# PLANNING BOARD REPORT PORTLAND, MAINE

“118 on Munjoy Hill”  
12 unit residential and 2 unit commercial condominium, 118 Congress Street  
Final Level III Site Plan and Subdivision  
Project ID 2013-255  
118 Condominiums, LLC (Ed Theriault), Applicant

| Submitted to: Portland Planning Board<br>Public Hearing Date: January 28 <sup>th</sup> , 2014 | Prepared by: Jean Fraser, Planner<br>Date: January 24 <sup>th</sup> , 2014 |

1 NORTH ELEVATION
1/8" = 1'-0"

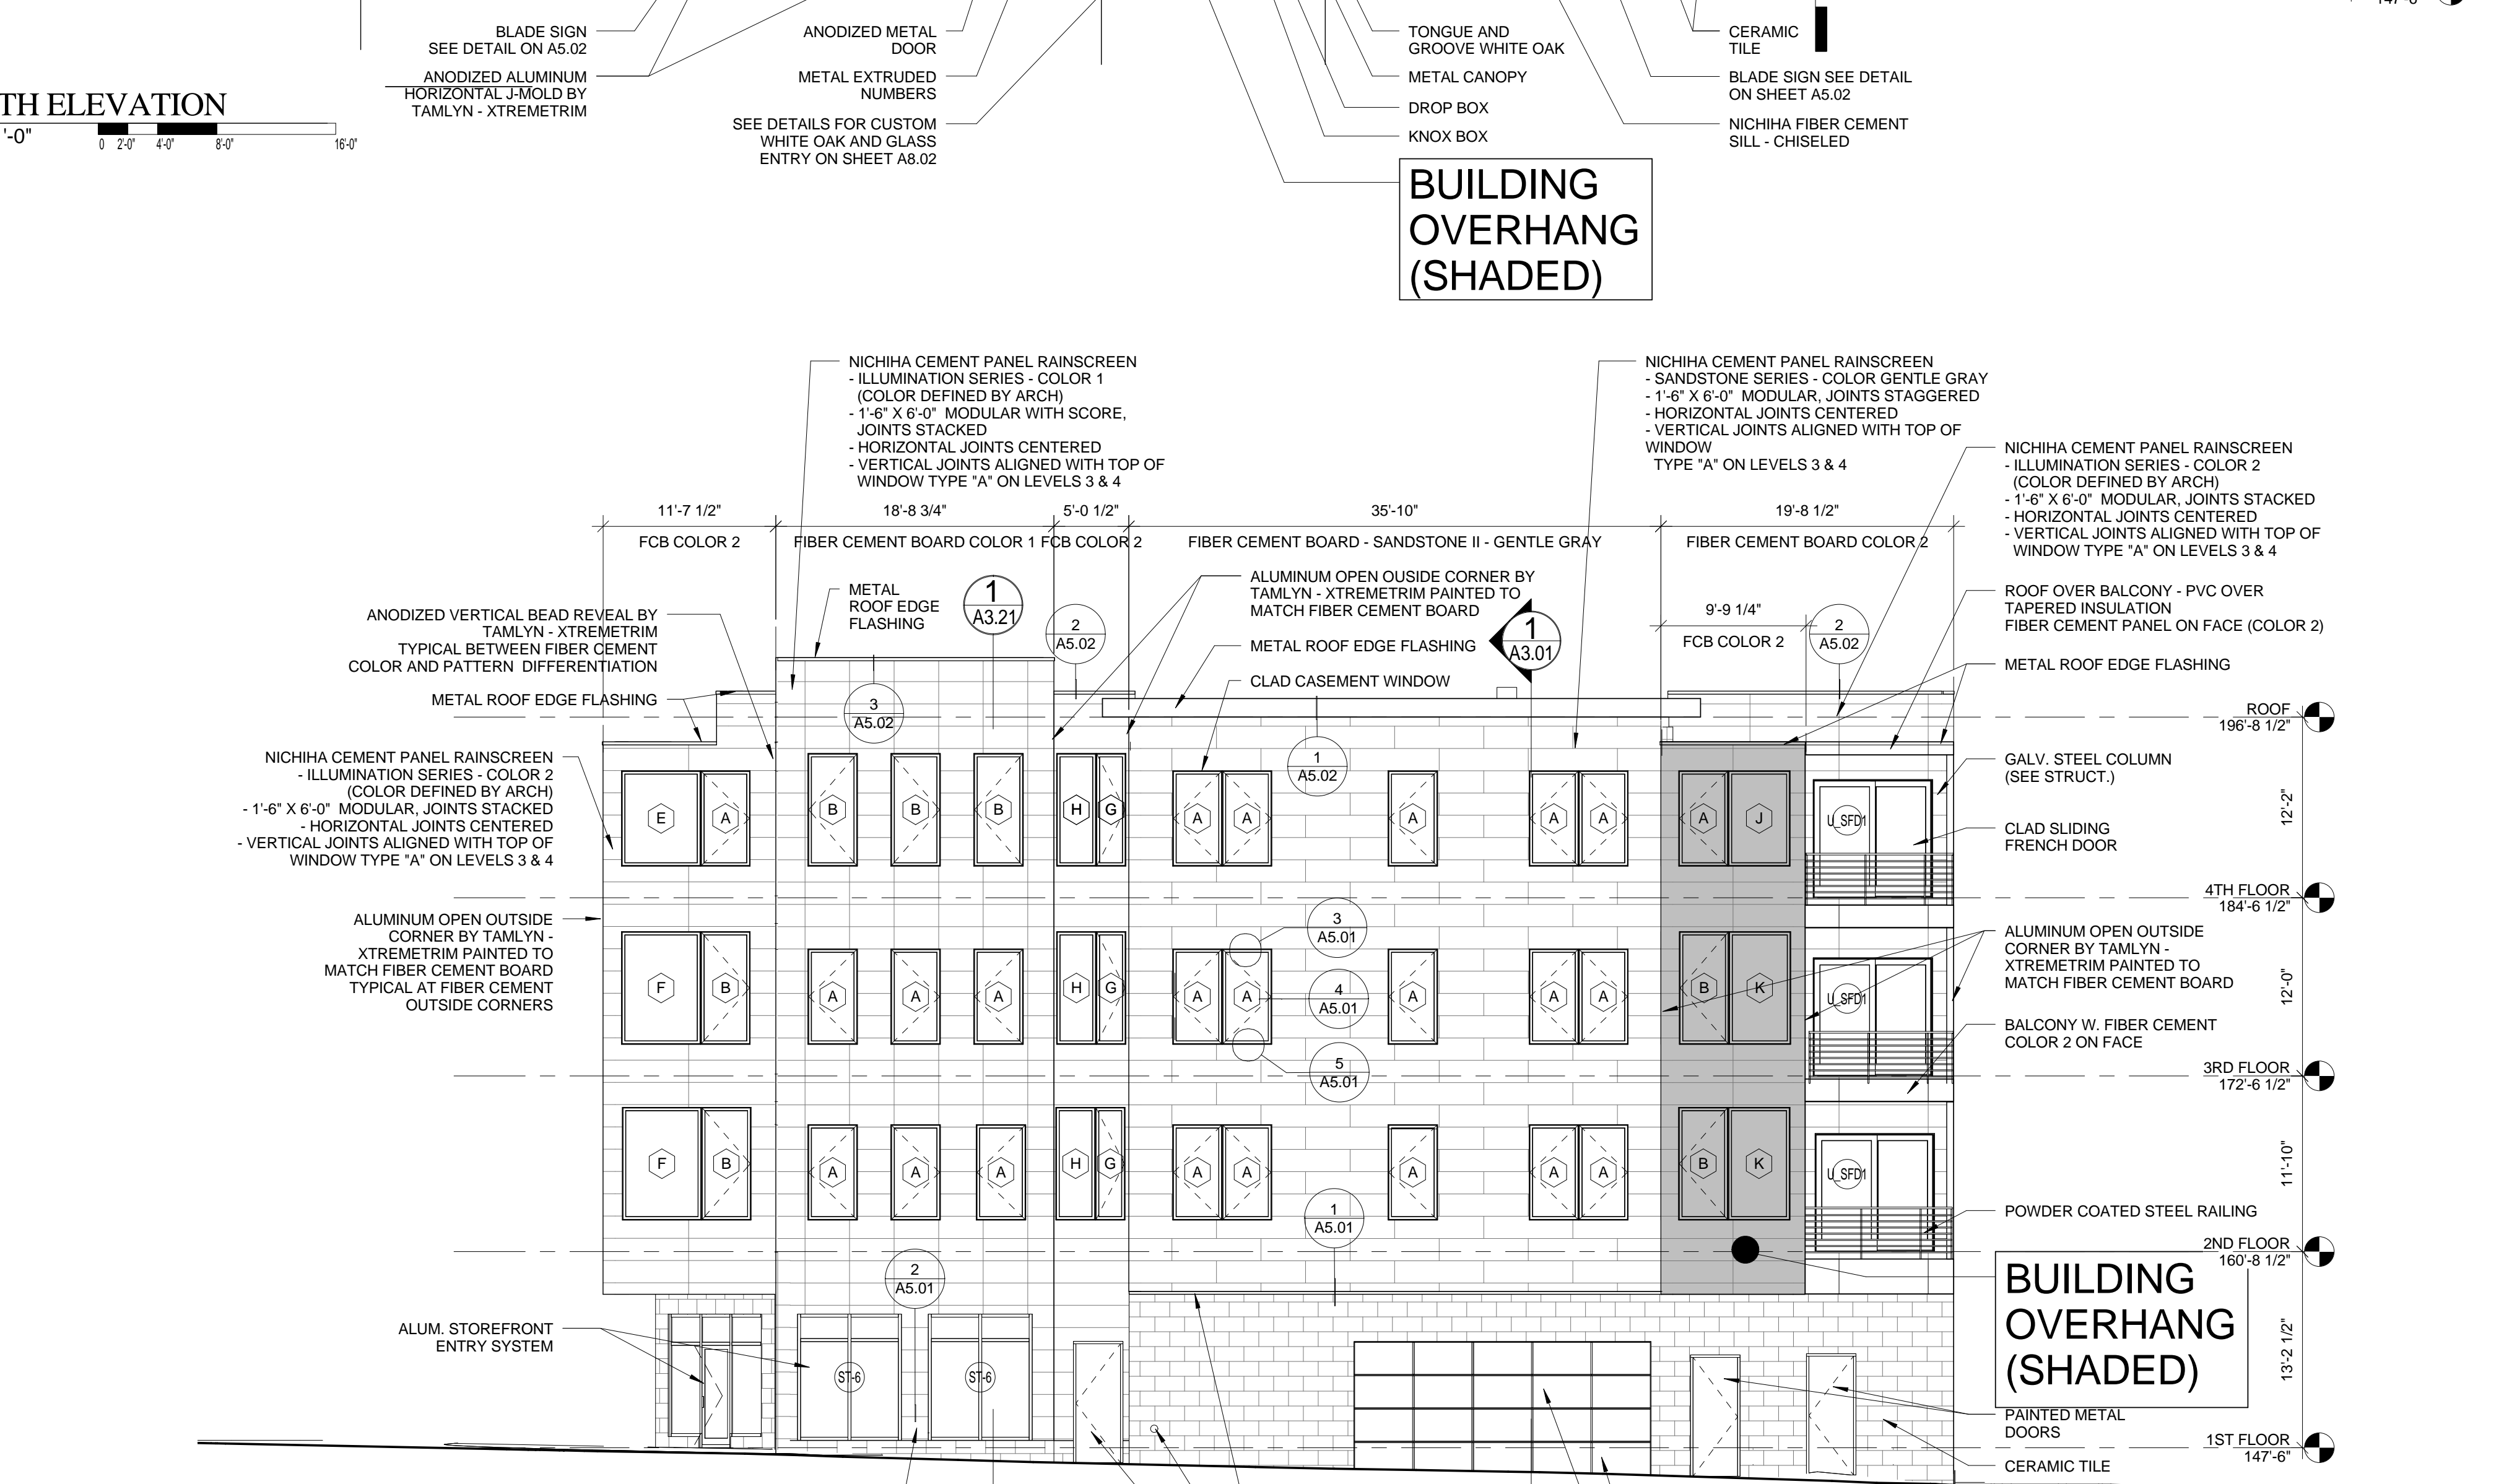
Although the applicant has set the building back one foot, the Congress Street decks (6 - each about 20 feet long) still overhang the ROW by 1ft 4 inches. On St Lawrence the three overhangs are 2ft 6 inches in depth and the entirety of this width overhangs the ROW (see note on Elevations in Plan P15 and Plans P12 and P22).

DPS still do not support any encroachments over the ROW and cite snow removal and falling ice as particular issues over the public sidewalk (Attachment 4). The Planning Board at the Workshop were concerned about the impact on the ability of the public to enjoy this section of sidewalk and requested additional views and graphics to understand how the overhangs and bulk of the building would relate to the public realm.

The City Arborist also is concerned about the overhangs in terms of the impact on street trees and views (Att. 6), and the Urban Designer notes that there is no compelling reason (eg site constraints or to maintain historic character) why the building can not be set back so that the balconies are within the property line (Attachment 7).

In regards to the architectural elements proposed to overhang the public right of way, unlike other exceptions where this kind of easement over the right of way was granted, this project is not limited by site constraints, existing structure, or by maintaining historical character. The articulation of the facade is a benefit to the streetscape and produces a good design that meets the design standards. If the Planning Board decides that the overhangs into the public right-of-way are not appropriate, then staff would encourage the resulting design solution maintain the current quality of design in regards to facade articulation and variation of form. (Attachment 7)

6  
L2.0  
NOT TO SCALE  
RAISED GRANITE PLANTER - PLAN VIEW

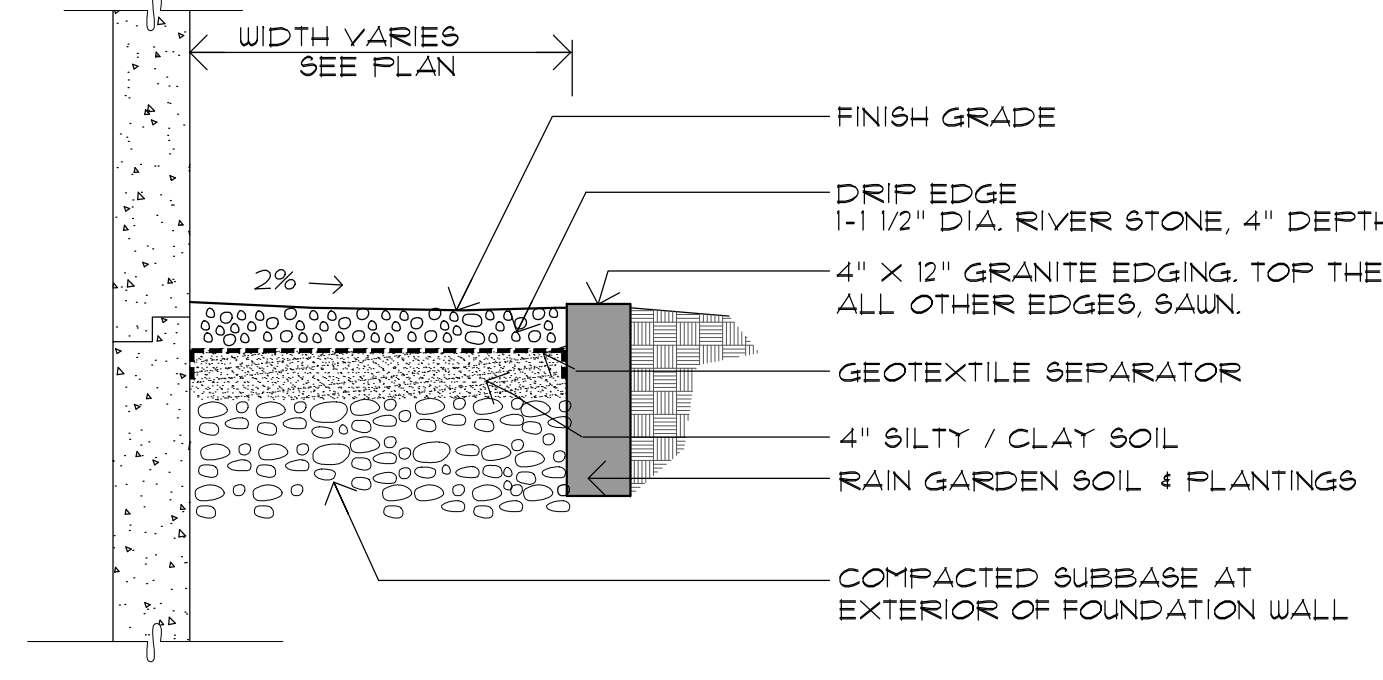
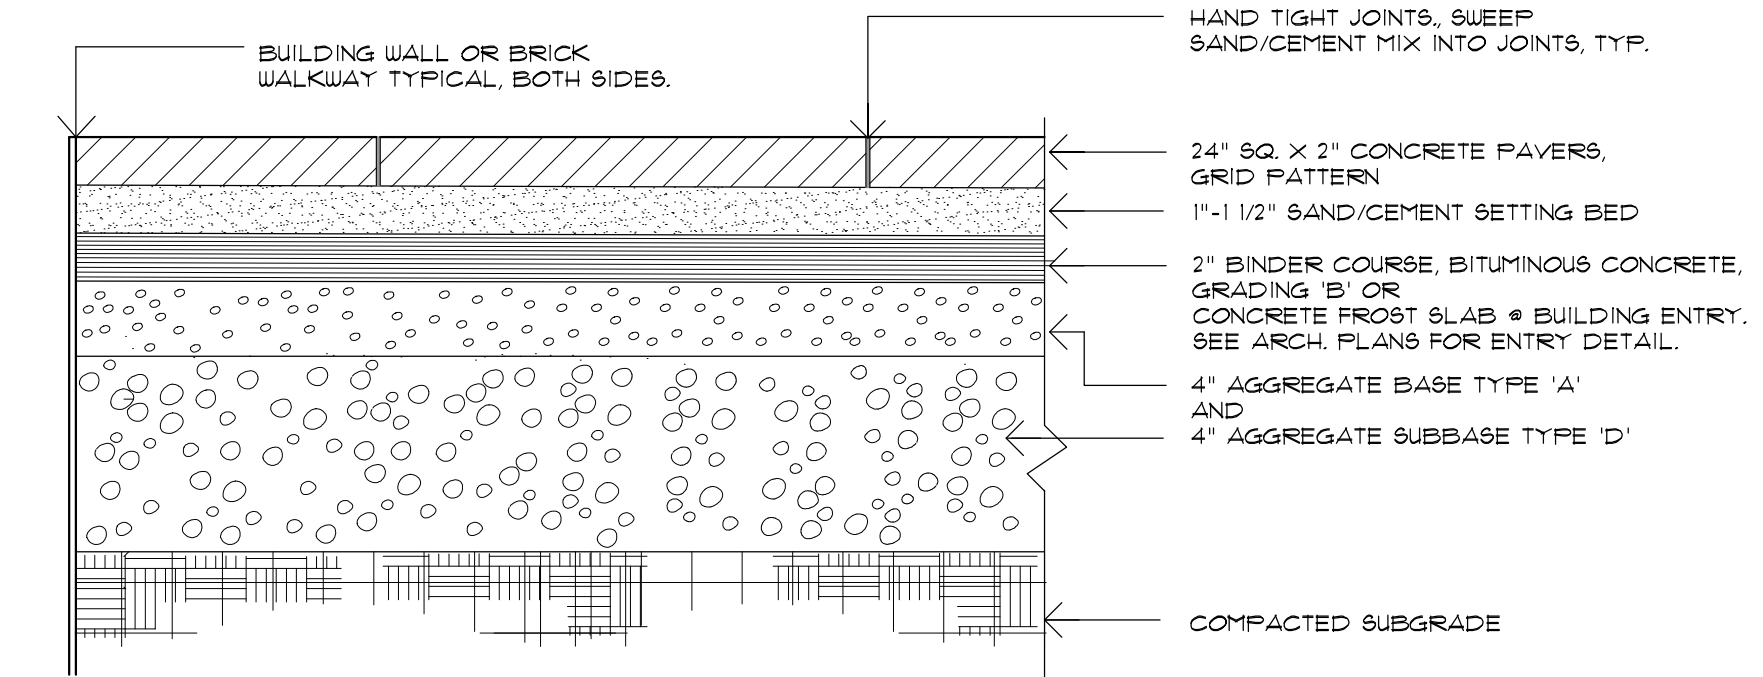
***Granite planters in right of way** - the six granite planters are proposed to be planted with street-trees and 'Cranesbill', perennial geranium. This will add interest to the typical mulched tree well. Long term however it is unlikely the city would be able to maintain these plantings. Ideally, the project could adopt the tree wells and maintain the landscape planting.*
